Pete Lien &
Sons
Concrete
Batch Plant

VA-19-002

LINDSAY DARDEN, PLANNER II

Land Development Code Analysis - Zoning

# CONCEPT SITE PLAN

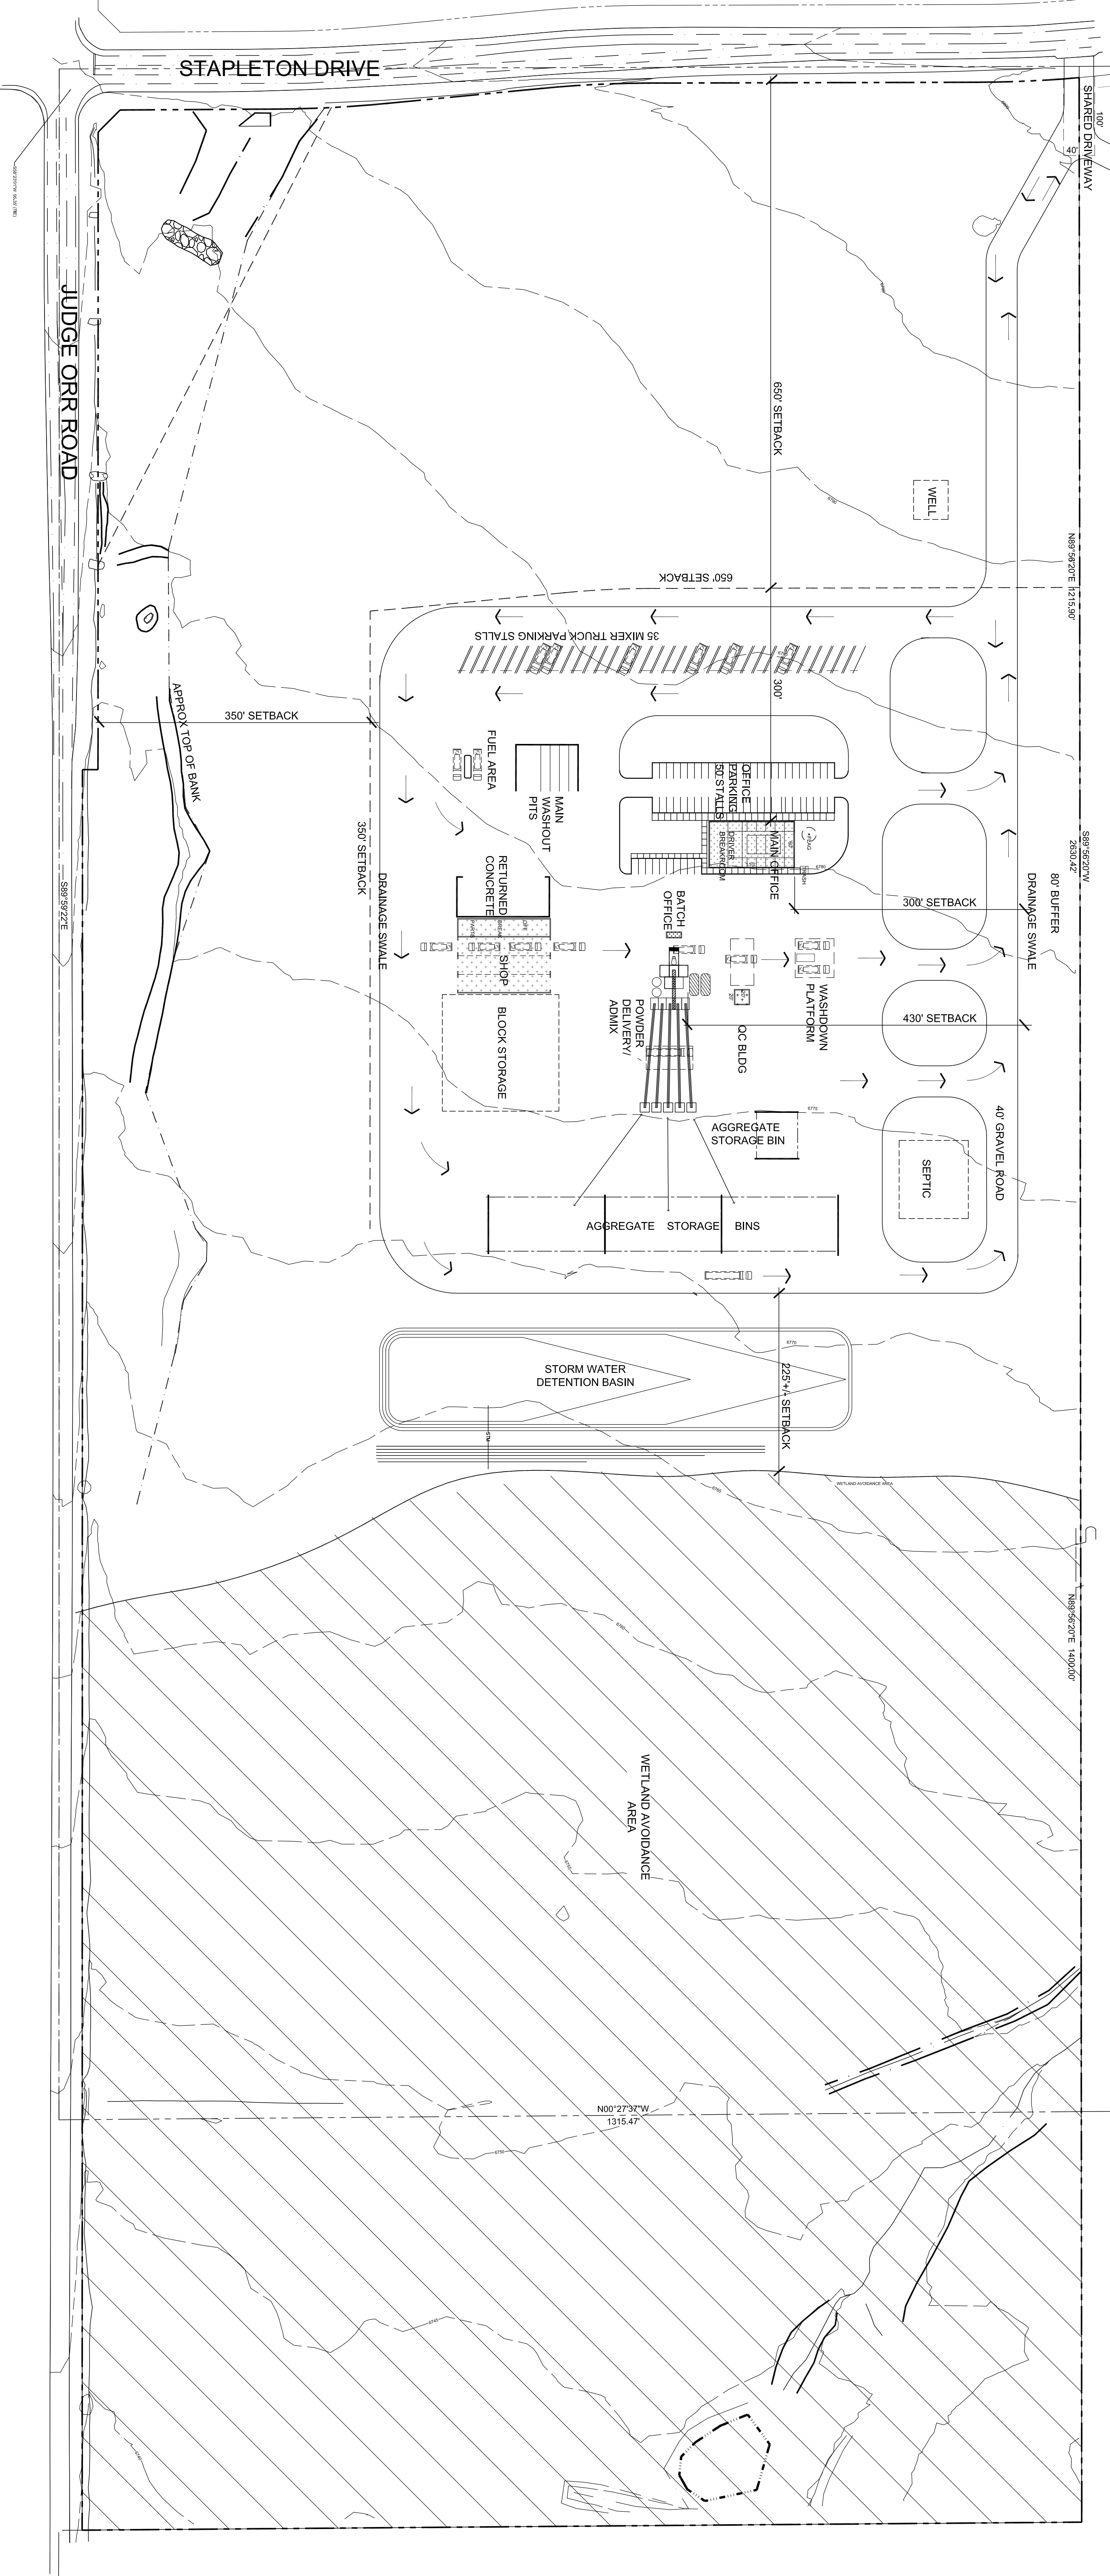
- The scale and overall massing of the proposed 72'-2" concrete mixer and conveyors may result in an inadequate visual transition from the surrounding low density residential and agricultural uses to the more intense and visually intrusive industrial batch plant use.

•Landscaping and additional buffer widths are proposed to mitigate those impacts; however, the height of the concrete mixer combined with the flat terrain will make screening and buffering of the visual impact difficult, if not totally impractical.

- The proposed site layout locates the taller structures near the center of the property, further from the property lines in an effort to help reduce the visual impact.

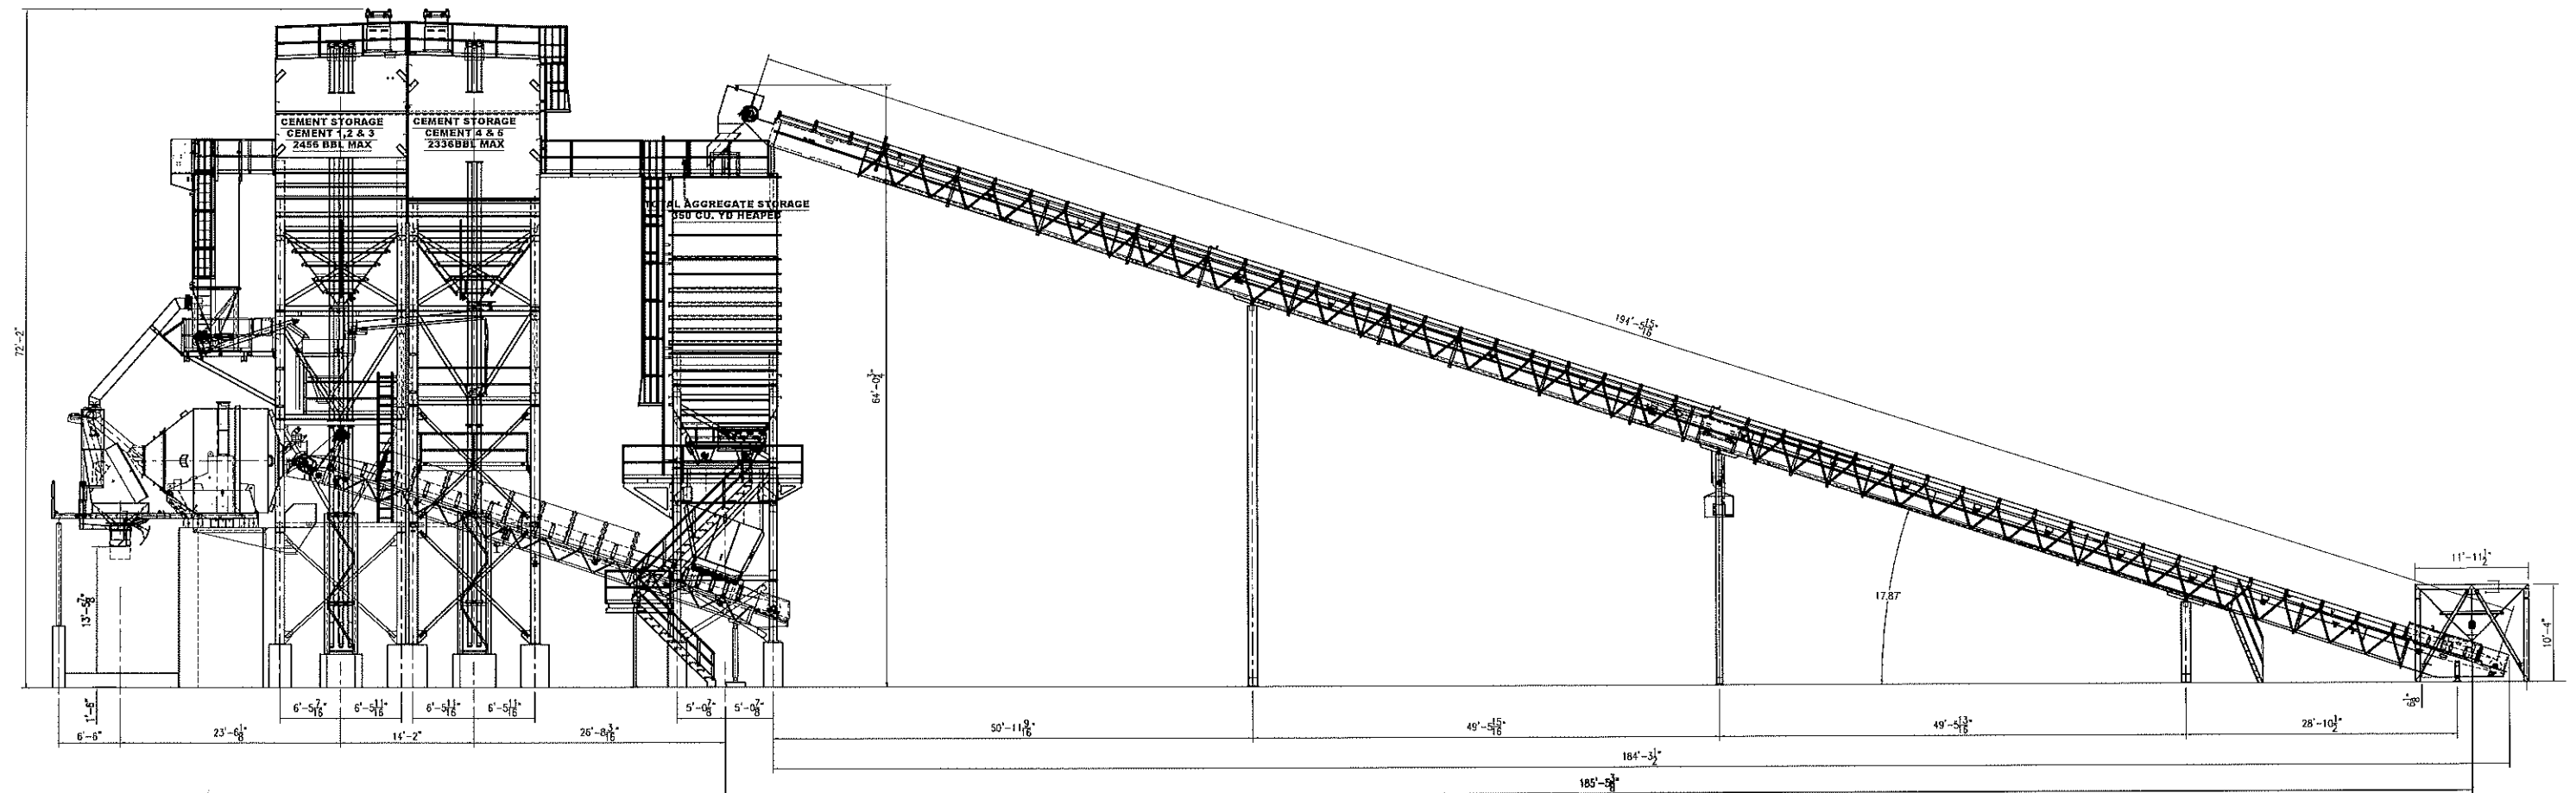
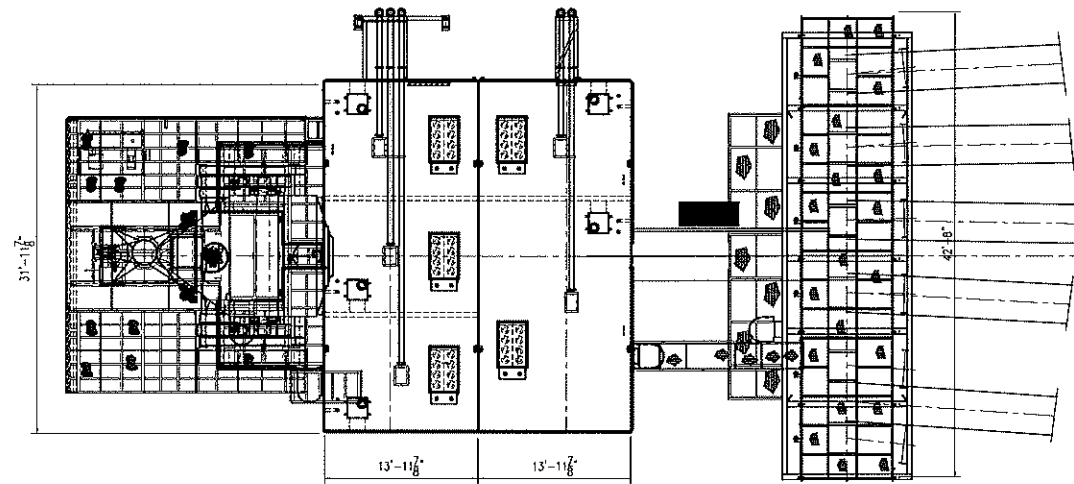
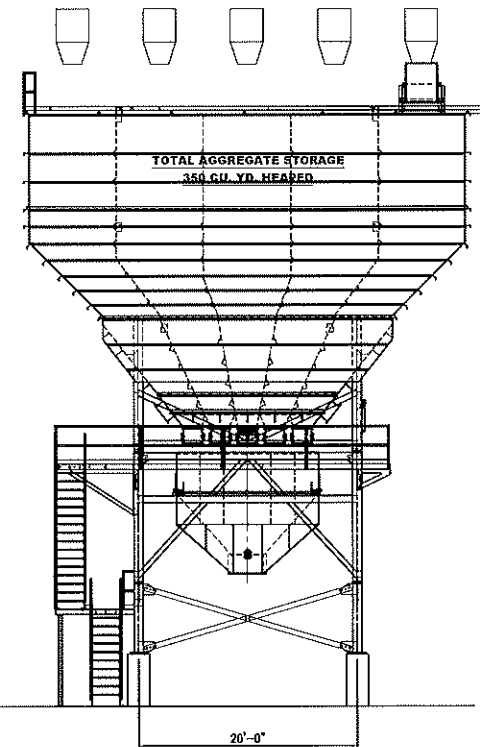
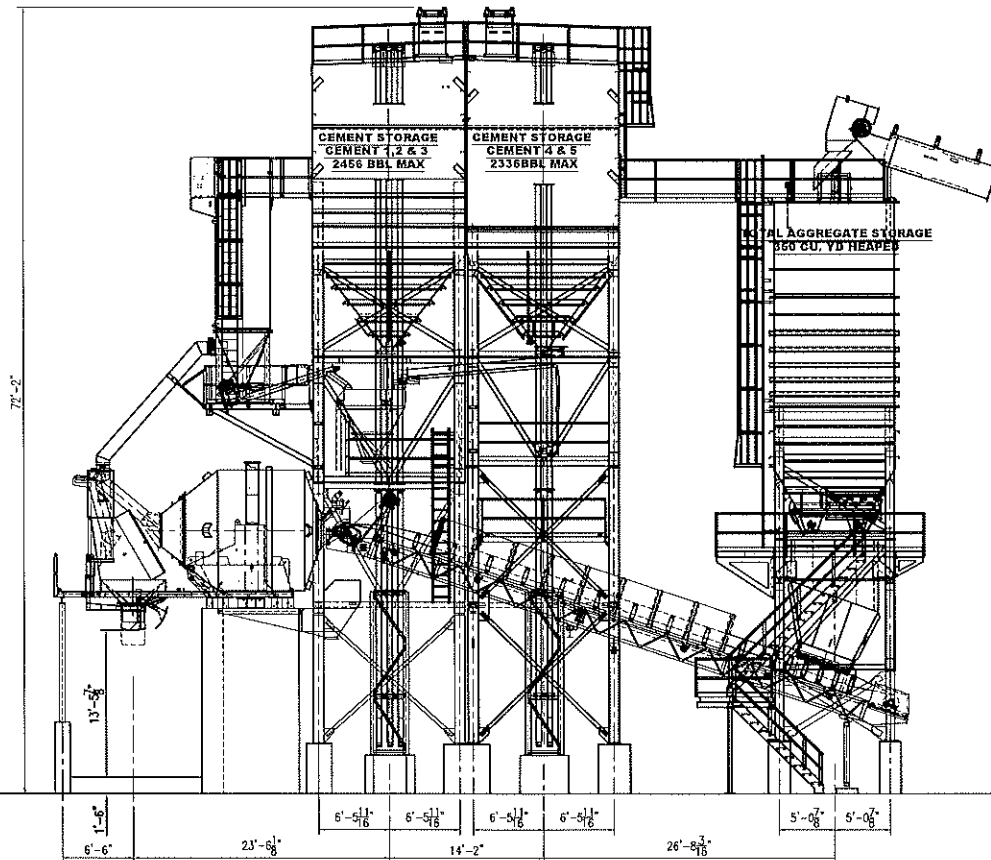
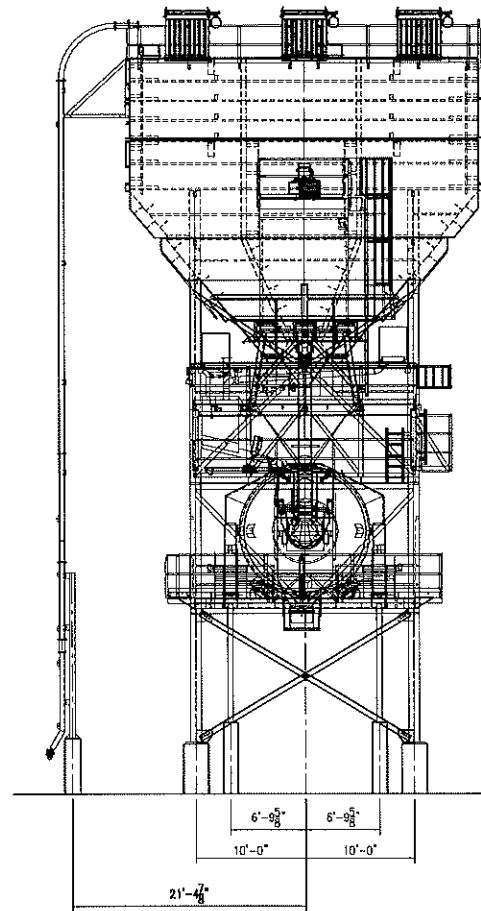
“One additional foot of height is allowed for each foot of additional setback provided above the required minimums up to a maximum of 100 feet.”
- The minimum setback requirement for structures in the A-35 (Agricultural) zoning district is 25 feet on all sides. The concrete mixer is proposed to be 72'-2" at its tallest point and located approximately 500 feet from the nearest property line.

- Applying footnote 10, the max. height allowed based on the additional setbacks provided is 505 feet; however, footnote 10 limits the max. height to 100 feet, which applies in this case.
 - $500 \text{ ft}(\text{proposed setback}) - 25 \text{ ft}(\text{standard A-35 setback}) = 475 \text{ feet additional setback provided.}$
 - $475 \text{ ft} + 30 \text{ ft} (\text{max. height allowed in A-35}) = 505 \text{ feet.}$

LANDSCAPE CONCEPT PLAN

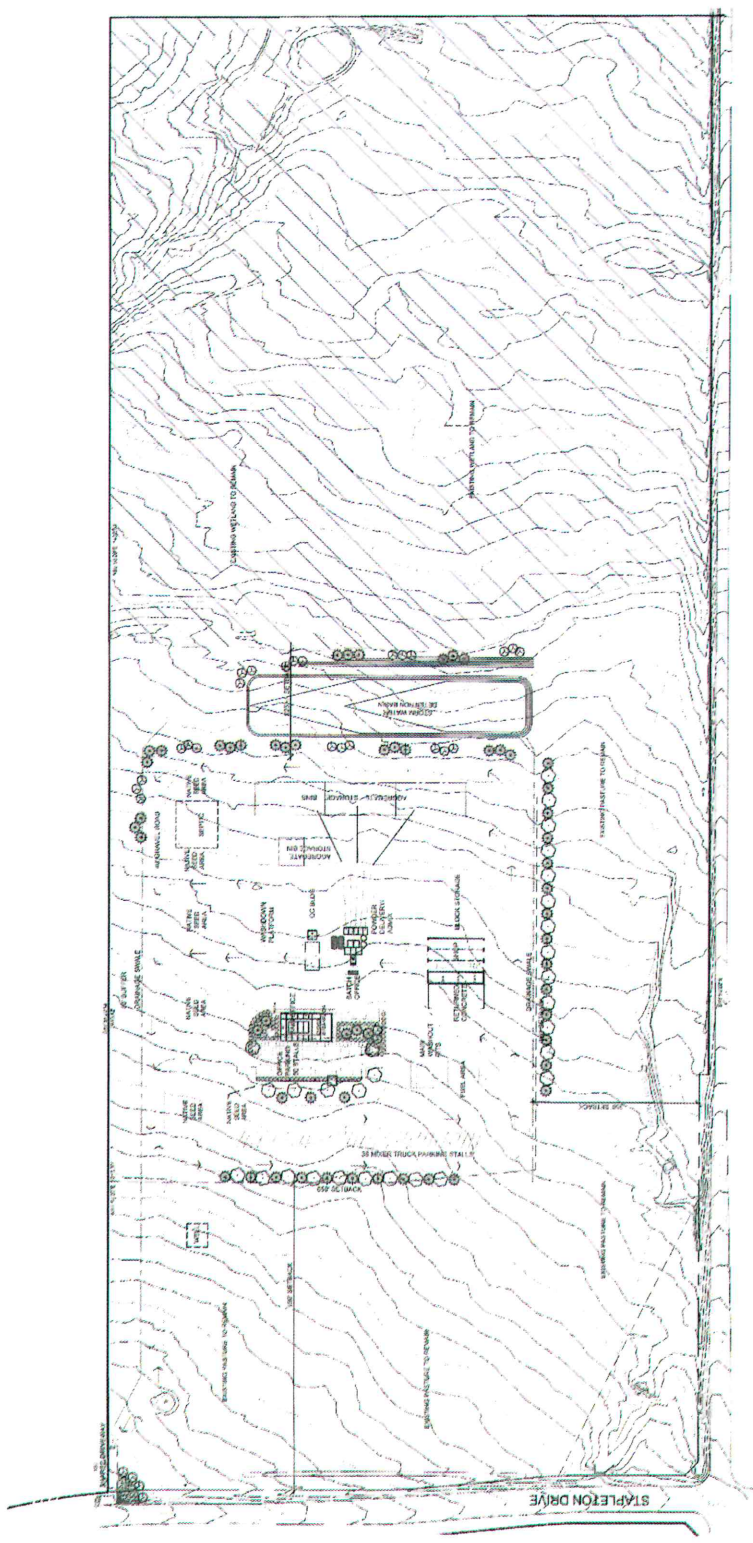
- Landscaping is proposed and a conceptual landscape plan has been provided
- Detailed landscape plan review shall occur at time of site development plan.

2. Screening and landscaping shall be installed prior to the initiation of the use and be in general conformance with the landscape plan submitted with the variance of use request.
